Arun District Council
Arun Civic Centre
Maltravers Road
Littlehampton
West Sussex BN17 5LF
Planning & Building Control General Enquiries
Tel: (01903) 737756 Fax: (01903) 730442
Dx: 57406 Littlehampton
Minicom: 01903 732765
e-mail: planning@arun.gov.uk
website: www.arun.gov.uk/planning

Application No: FP/248/20/PL
Site Address: Land north of Felpham
Description of works: Revised details relevant to the sport pitch & changing facilities building (previously approved under Y/38/09/). This site also lies within the parish of Yapton & is in CIL Zone 4 (Zero Rated) as other development.

Thank you for your internet representation made on 19th April 2021 which has been recorded as no objection with the comments as follows:

Drawing Title:
CHANGING FACILITIES BUILDING

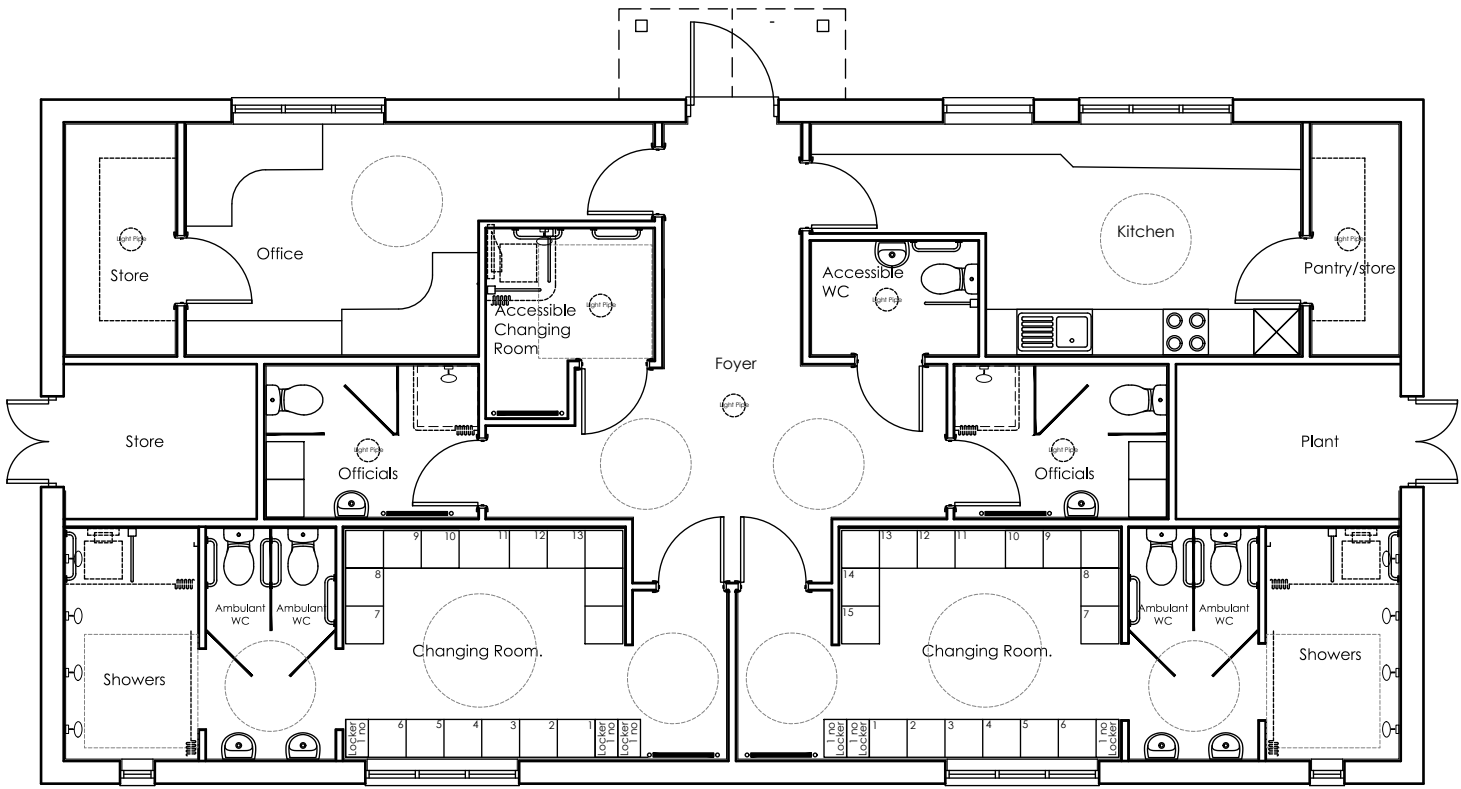
- 2) Two Changing rooms for up to 6 teams?? Is there to be scheduling to ensure that all the pitches are not in use at the same time? What was the original ADC specification for the number of pitches?

- 3) Practicality and suitability: Why is there an office and full size kitchen? A waste of space and more expensive for the kitchen! Far better to have two smaller changing rooms to cater for the 5 a side pitches and maybe just a small "tea room" able to provide hot/cold drinks/drinking/running water. Is this a Sports Council requirement?
